Tween Bridge Solar Farm

9.2 Statement of Common Ground with City of Doncaster Council

Document Reference: 9.2

Revision 3

Following ongoing consultation with stakeholders an additional figure (Figure 4) has been included to identify areas of archaeological and geoarchaeological sensitivity

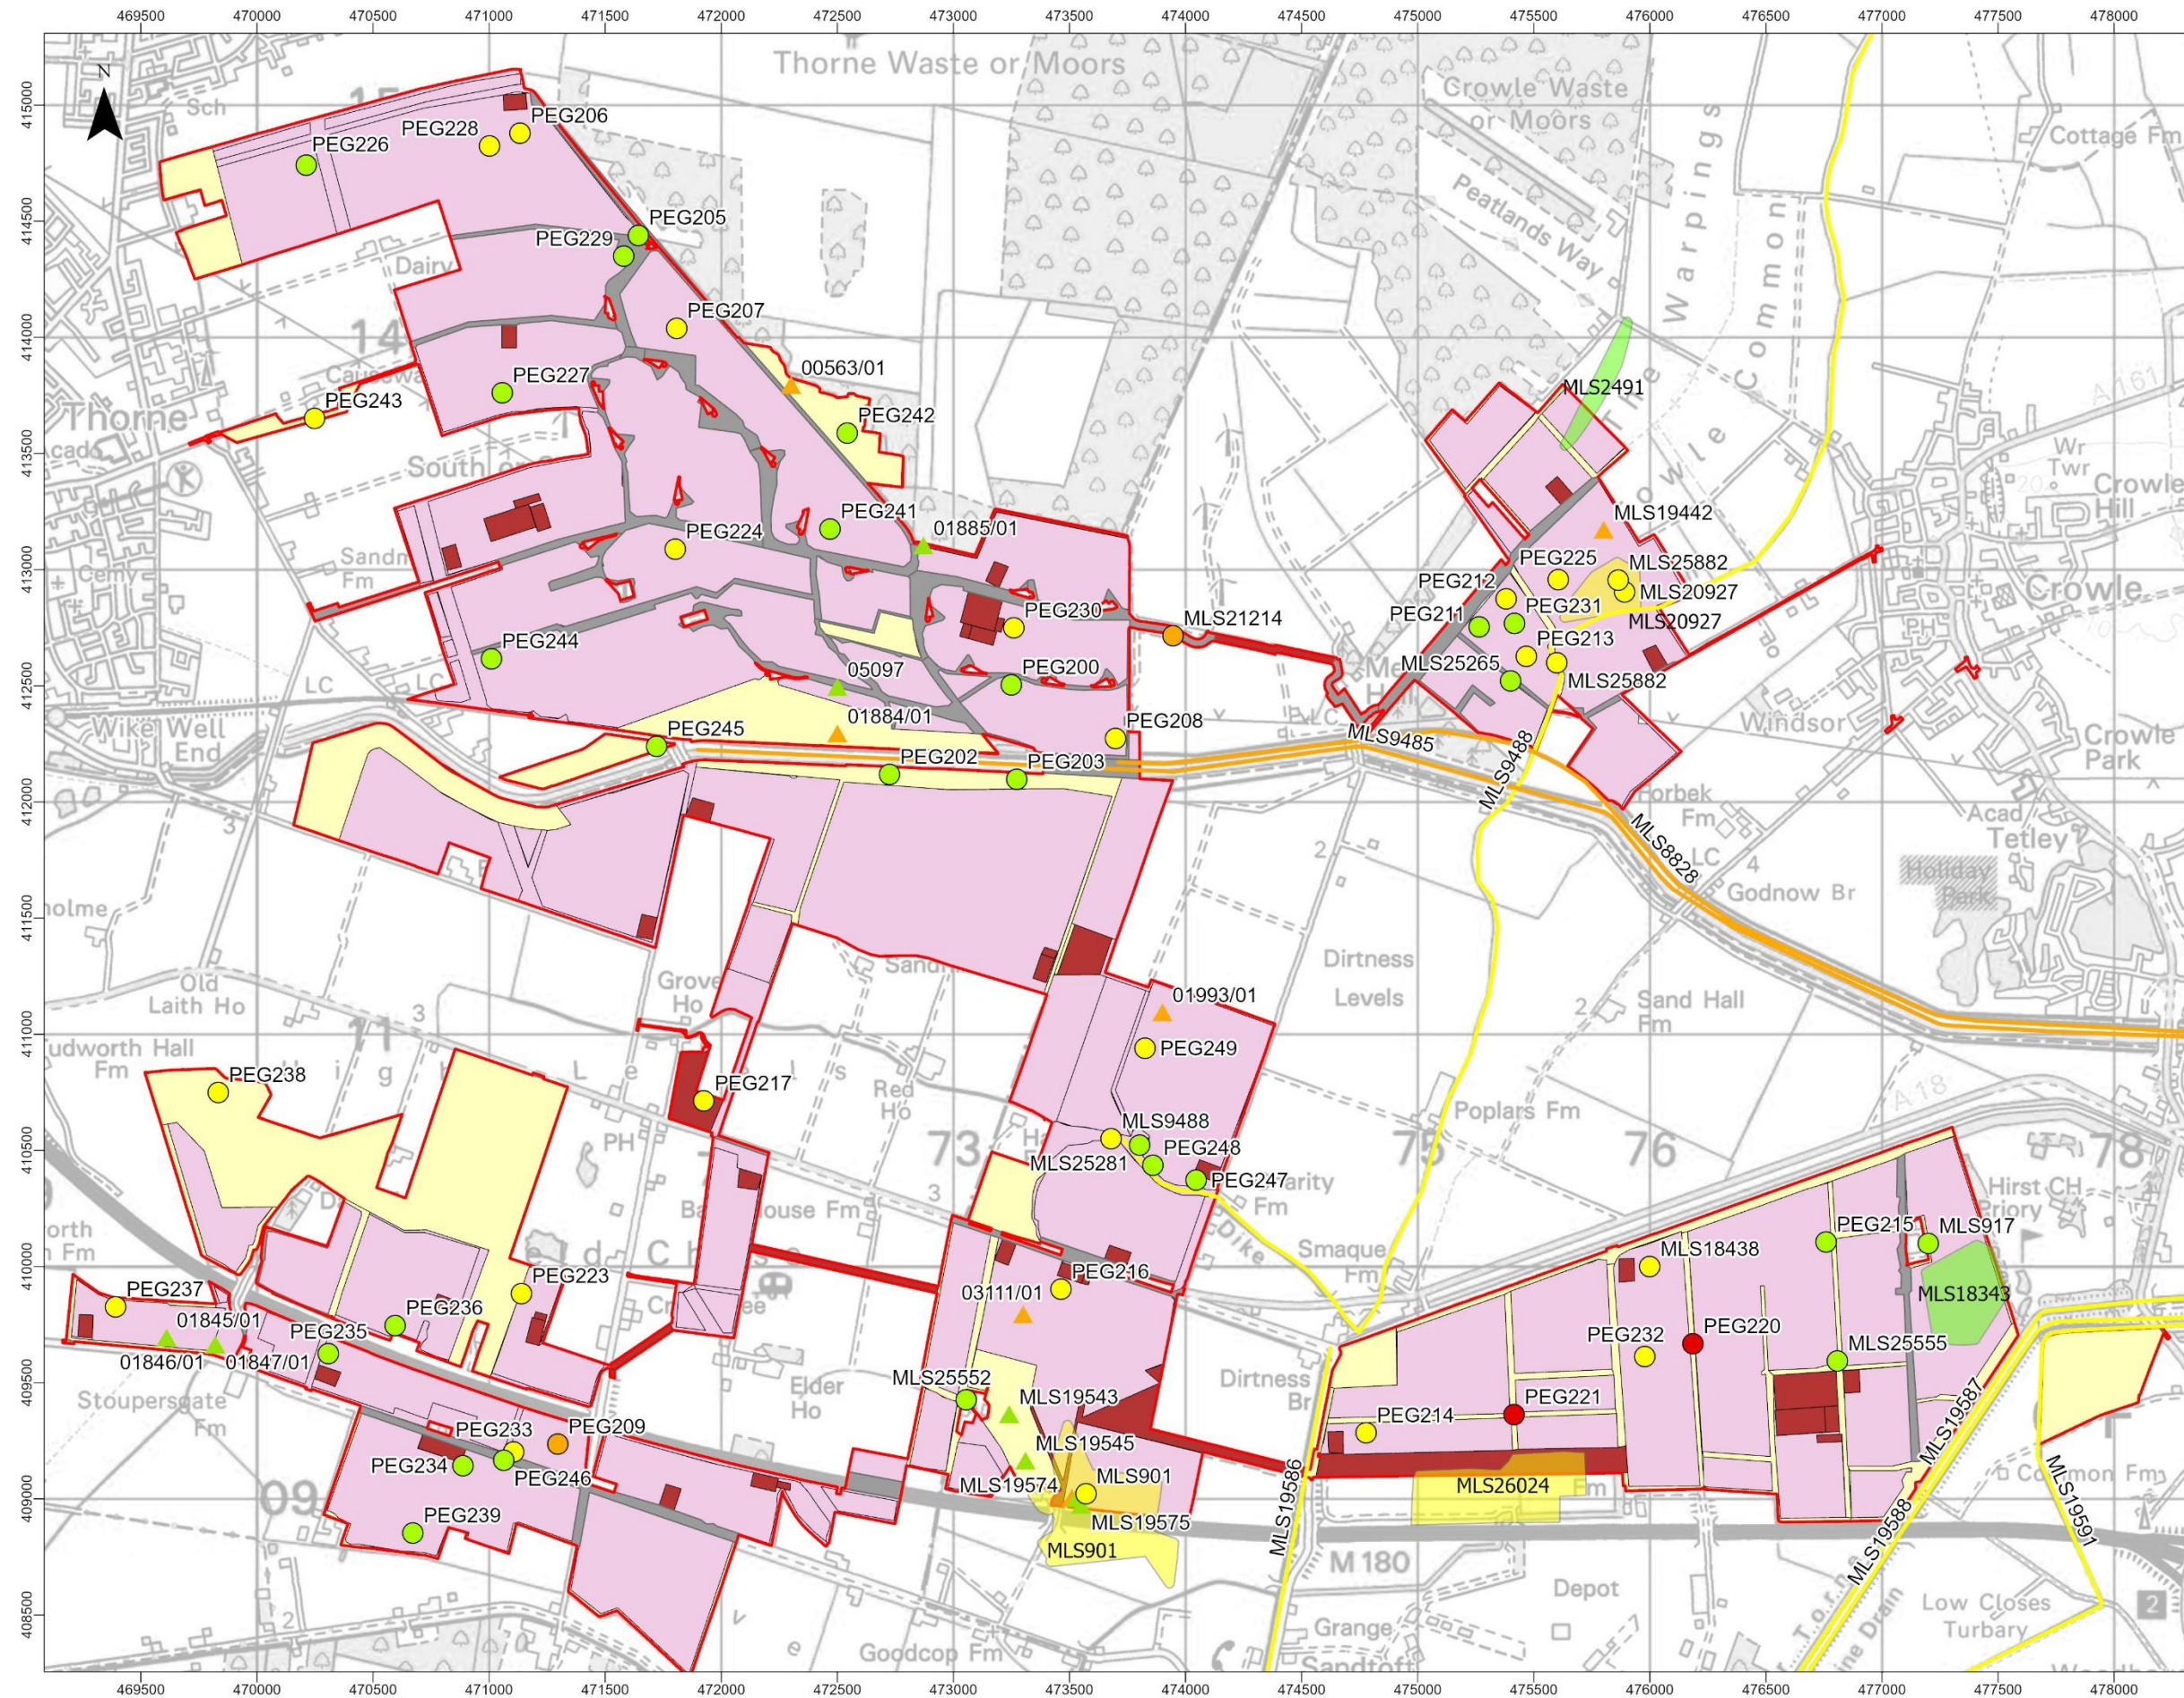
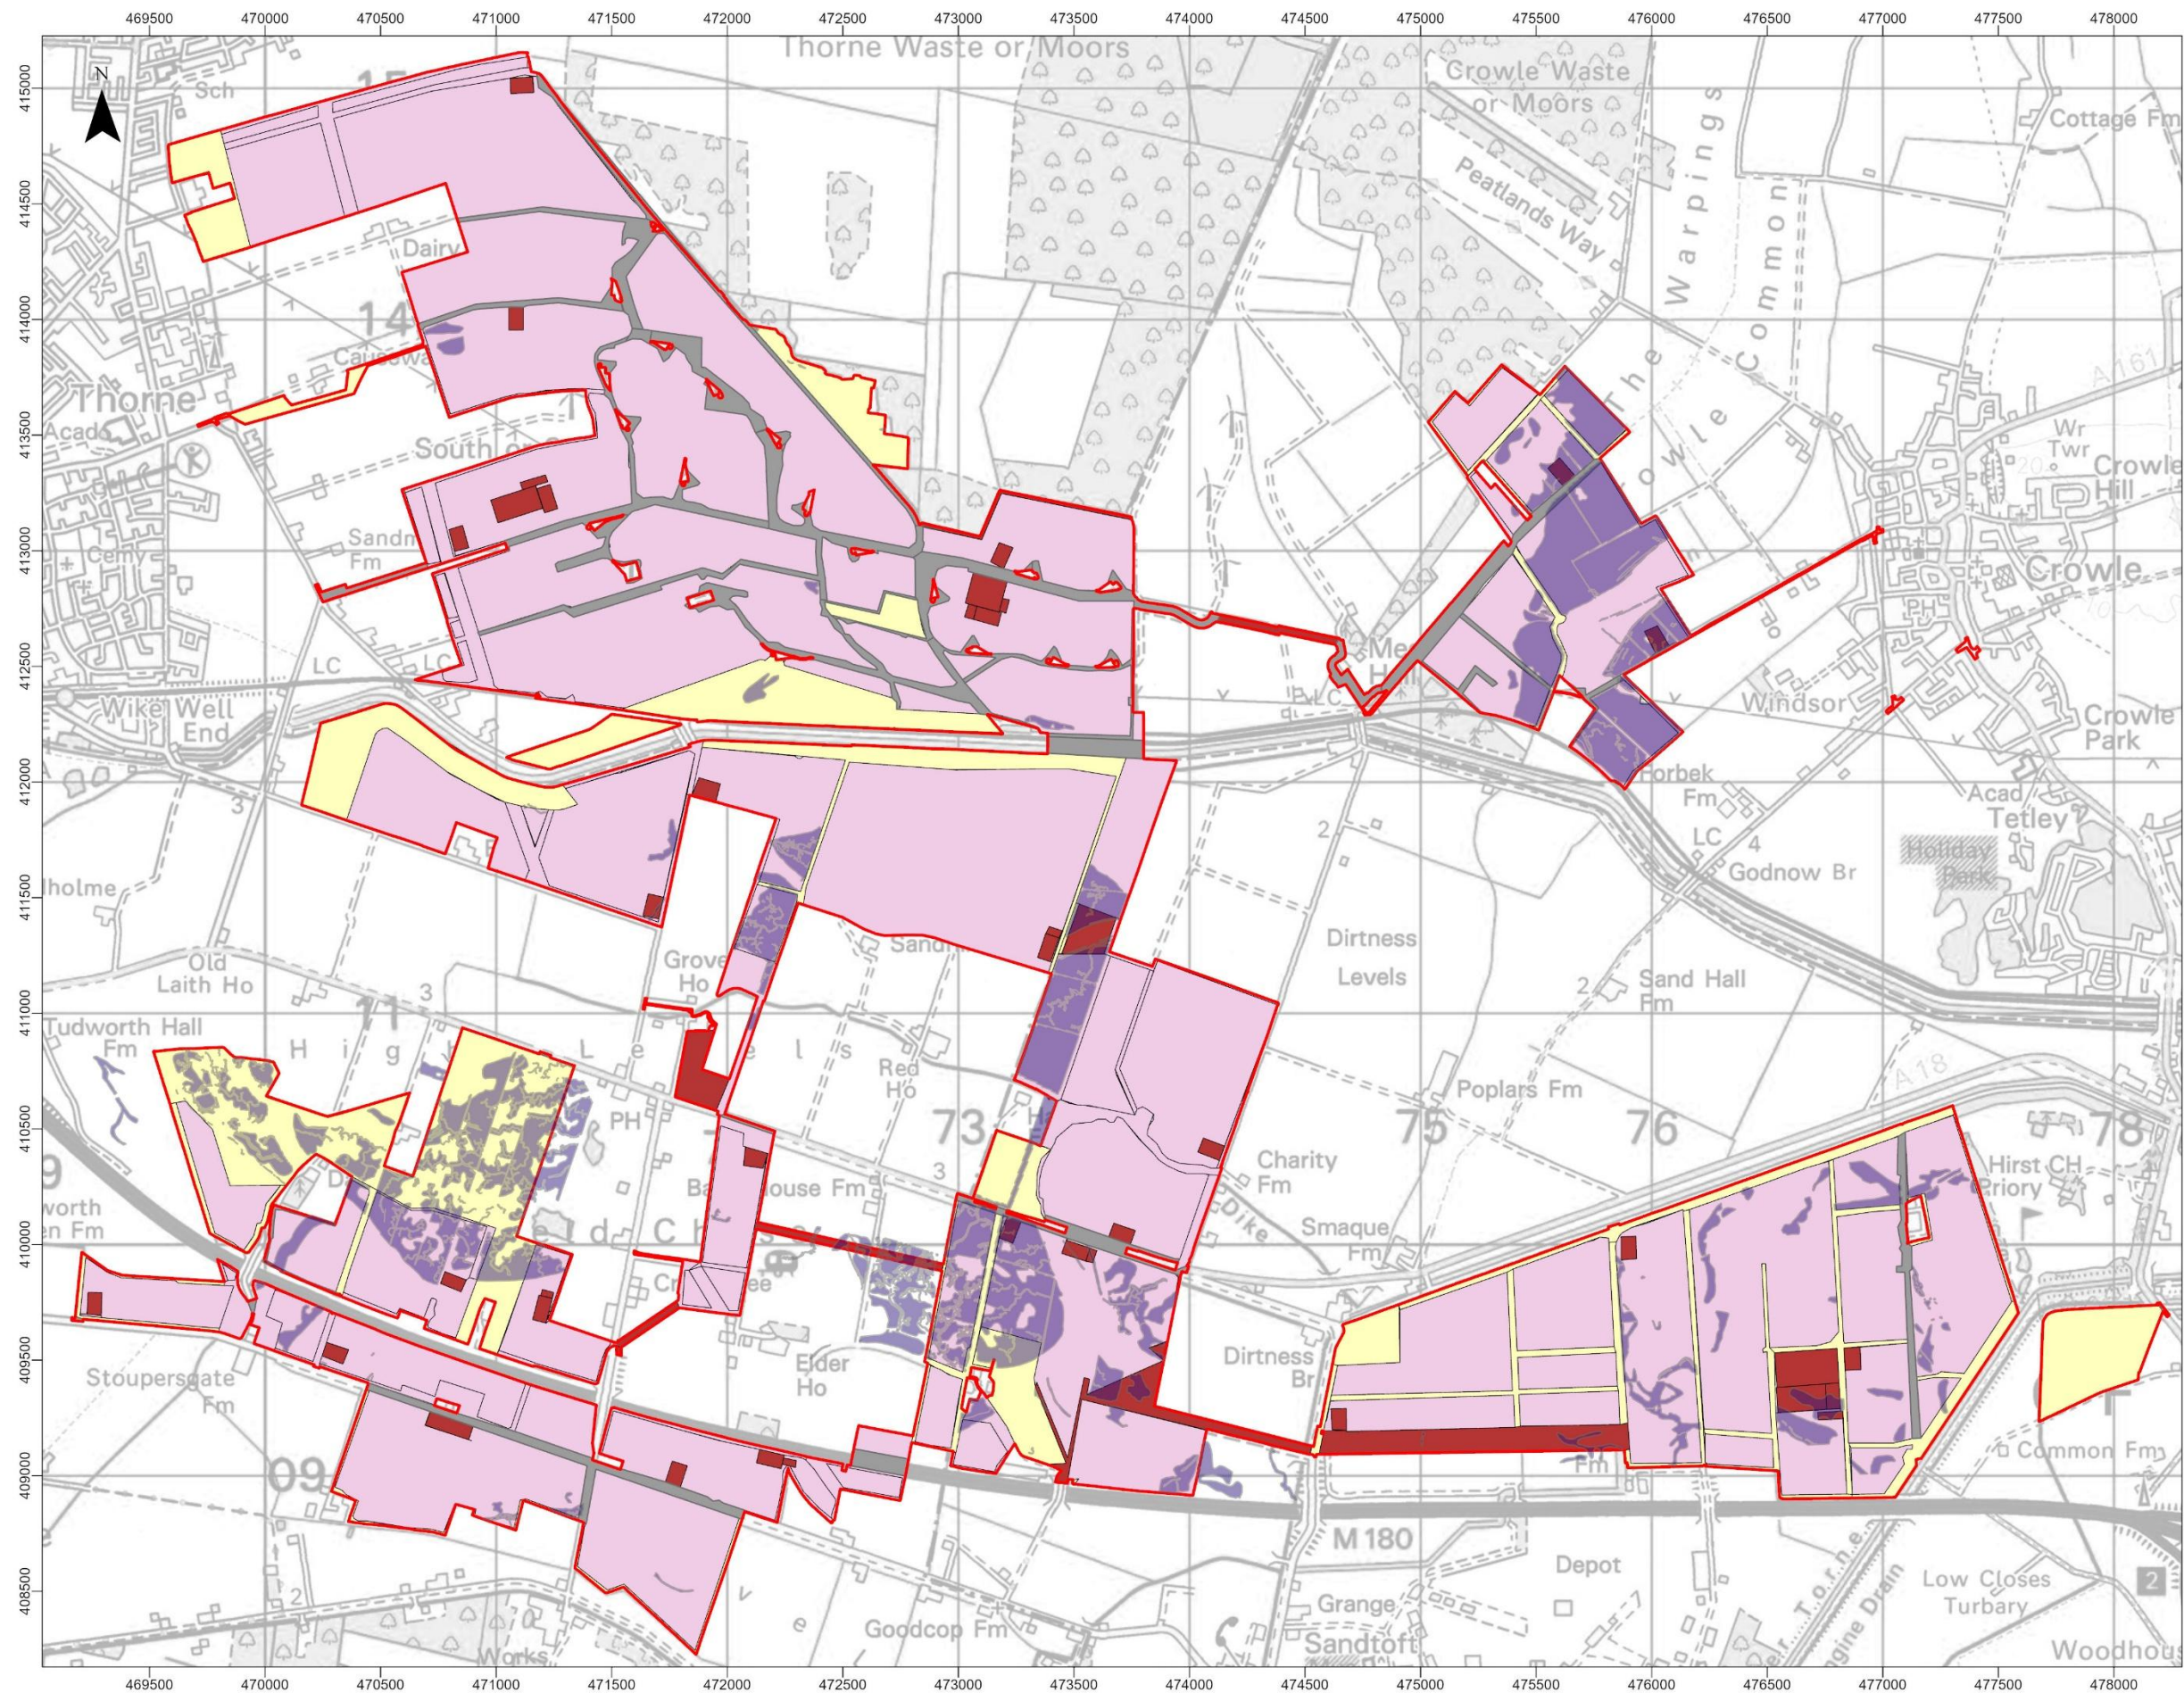
Ref	Topic	City of Doncaster Council Position	Applicant Position	Status
			It is the case that a full suite of evaluation has taken place to inform the assessment of the Scheme.	
		Paragraph 8.18 of RR This archaeological mitigation strategy is actually an archaeological evaluation and mitigation strategy that the applicants propose should be undertaken post consent. However, determining the impact of a proposed development upon potential archaeological remains is something that needs to be understood prior to determination so that appropriate planning weight can be afforded. To not do so could lead to harm to archaeological remains or inappropriate mitigation post-consent. Perhaps a useful compromise would be to evaluate the areas of high impact construction activities such as below ground cable routes, directional drilling access pits, temporary compounds, BESS and substations at this stage so that any issues could be addressed in a more timely fashion.	The approach to assessing potential impacts to the archaeological resource within ES Volume 2 Chapter 8: Cultural Heritage and Archaeology [Document Reference 6.2.8 Revision 3] has been precautionary with a worst-case scenario employed to ensure adverse effects are clearly articulated and due weight given to these. The exact routes and construction details for the higher impact elements of the Scheme would be developed as part of the detailed design of the Scheme and secured by requirement, notably requirement 6 of the Draft Development Consent Order [Document Reference 3.1 Revision 7]. The Applicant is confident that any potential evaluation or mitigation required within these areas can be delivered in a timely fashion post-consent. The Outline AMS [Document Reference 6.3.8.6 Revision 3] has been amended to	Not Agreed

Ref	Topic	City of Doncaster Council Position	Applicant Position	Status
			include a zoning plan following comments received from SYAS on behalf of CDC.	
9		Paragraph 8.19 – 8.20 of RR Where the oAMS specifies mitigation measures rather than evaluation techniques, SYAS is broadly in agreement with the proposals. Micro-siting should be added to the options specified in paragraph 5.10 as another method of avoiding archaeological impacts. As we were not given the opportunity to review the strategy before submission, there are a number of minor revisions that should be added: • Details arrangements for monitoring the fieldwork by local authorities should be included • The oAMS should use the language of the DCO stating in paragraph 5.11 that site specific WSIs “will be substantially in accordance with this strategy”	The Applicant acknowledges the broad agreement. The Applicant has considered the comments provided and will continue to engage on the ES Technical Appendix 8.6 Outline Archaeological Mitigation Strategy [Document Reference 6.3.8.6 Revision 3] to ensure the approaches detailed are acceptable to the City of Doncaster Council. The Applicant has prepared a revised Outline Archaeological Mitigation Strategy [Document Reference 6.3.8.6 Revision 3]. Requirement 12 of the Draft Development Consent Order [Document Reference 3.1 Revision 7] secures the Outline AMS by stipulating that the written scheme of investigation for each development phase must be substantially in accordance with the Outline AMS. Requirement 12 also provides approval rights to the relevant local planning	Agreed
